R/192/21/L

Hobbs Farmhouse 36 Sea Lane Rustington BN16 2RE

Listed building consent for erection of single storey rear extension to create orangery and creation of en suite on first floor following the demolition of existing outhouse.

Drawing: Existing Plans

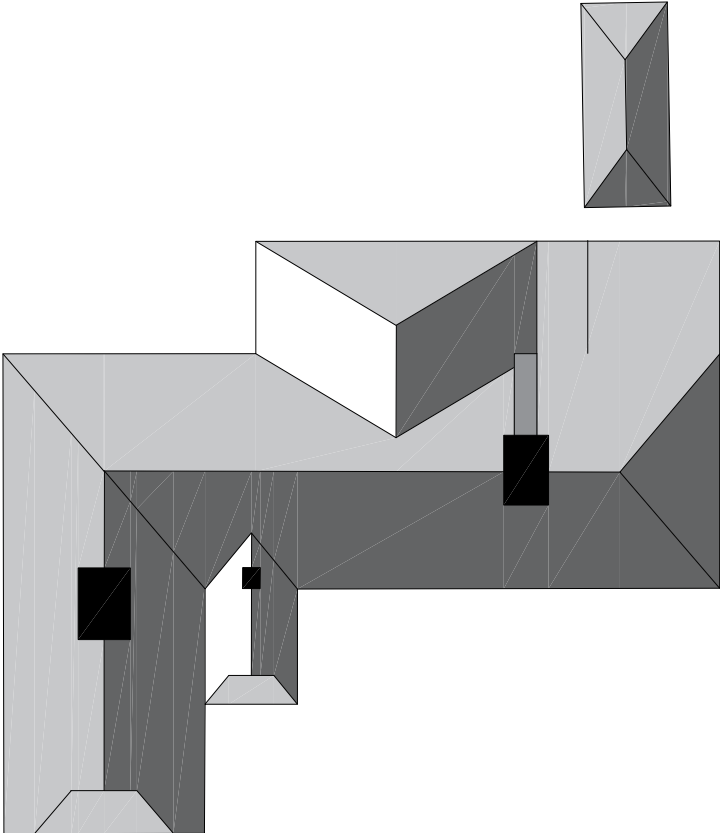
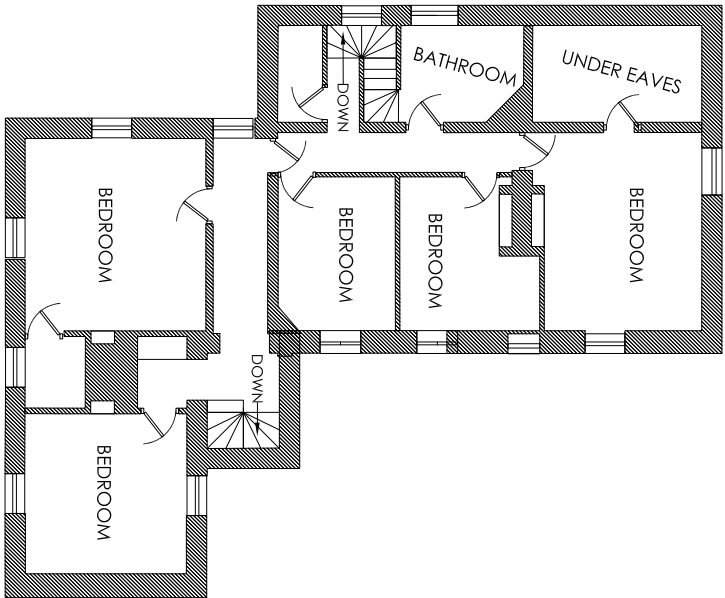
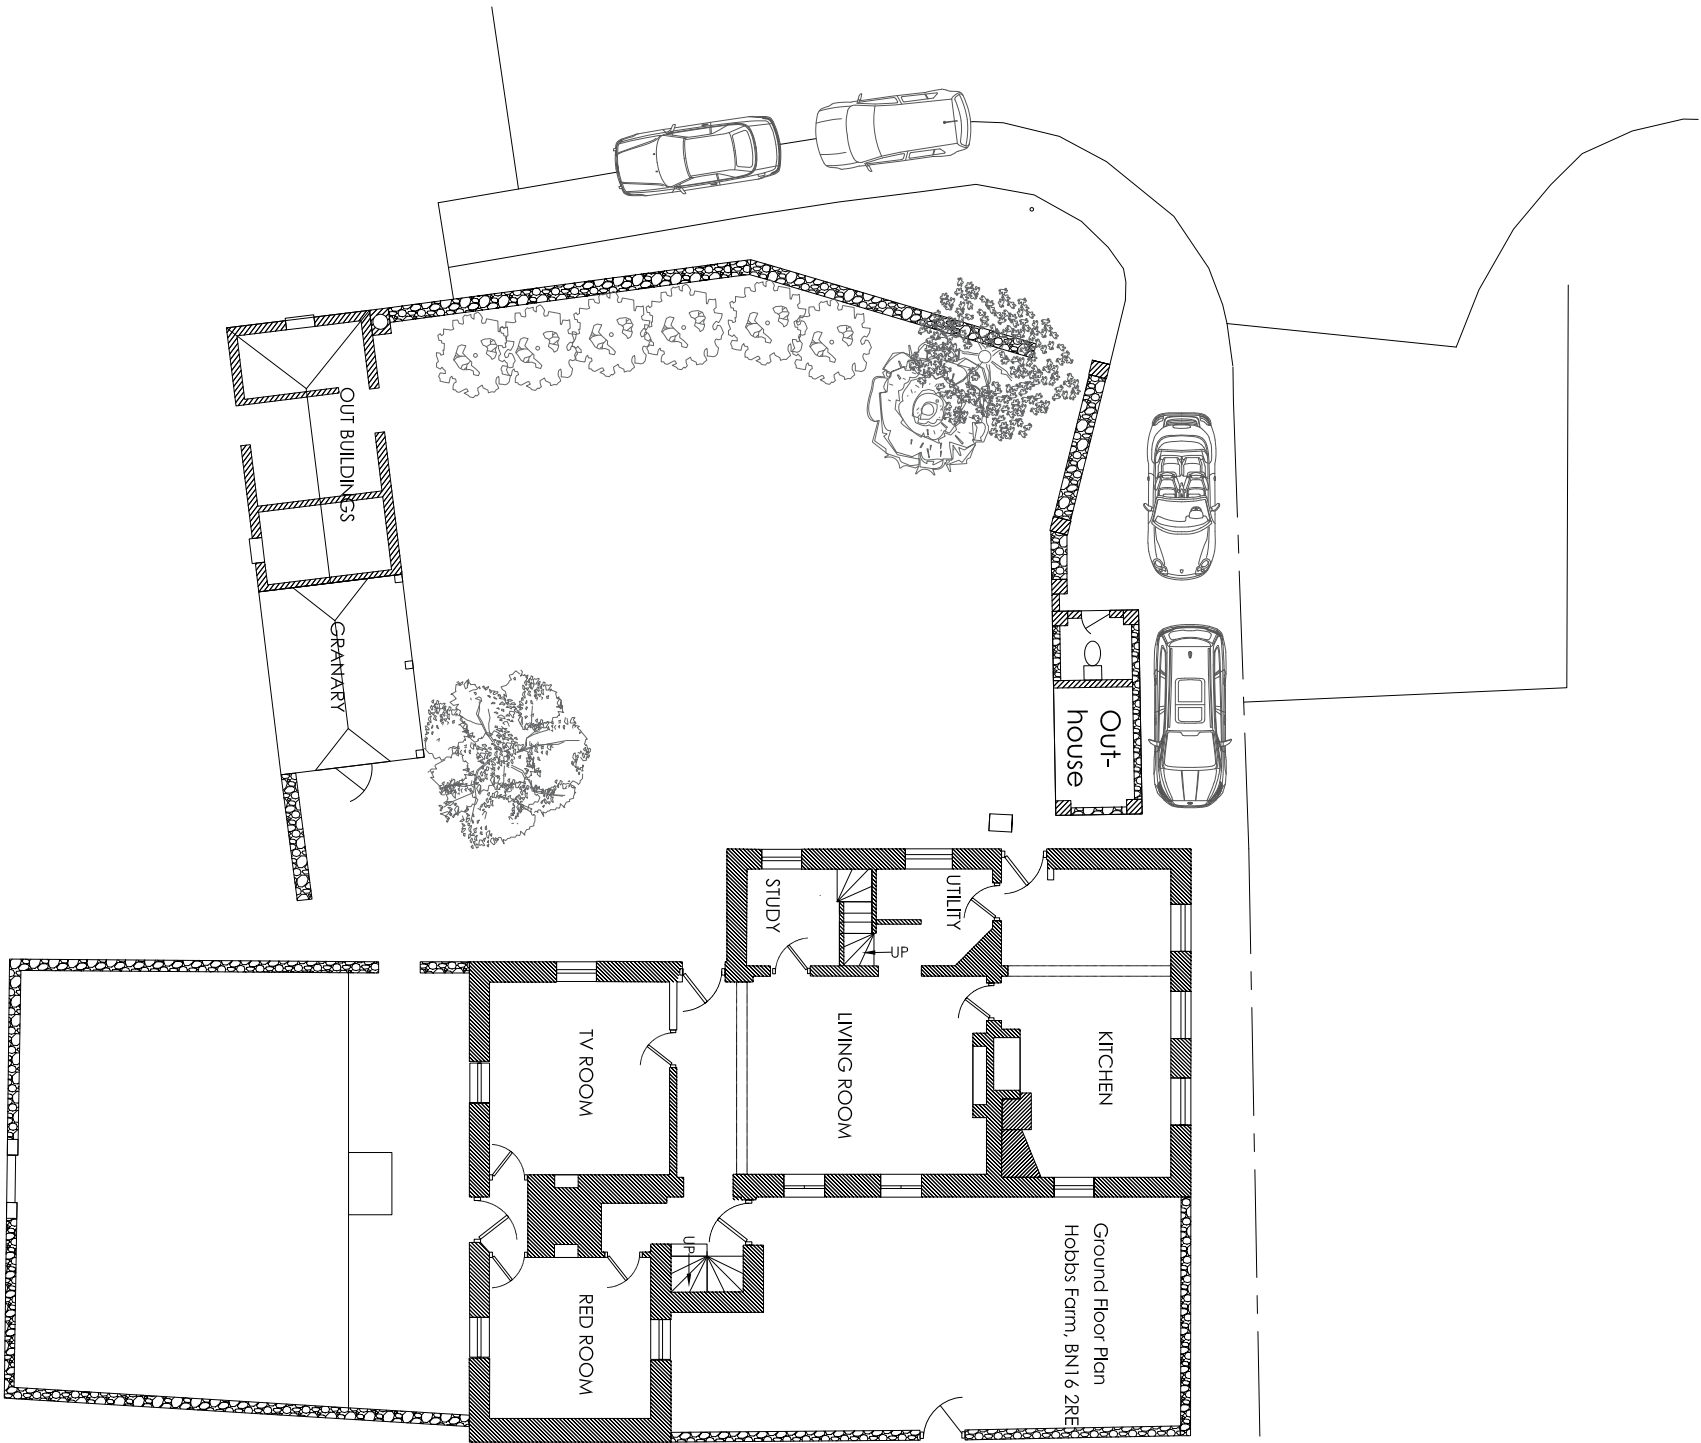
The small structure to be demolished appears on the OS map of 1911-12. The brick work of the structure is attractive, but clearly reads as something from that time as opposed to something similar to the main listed building. It is small in scale and of no great significance.
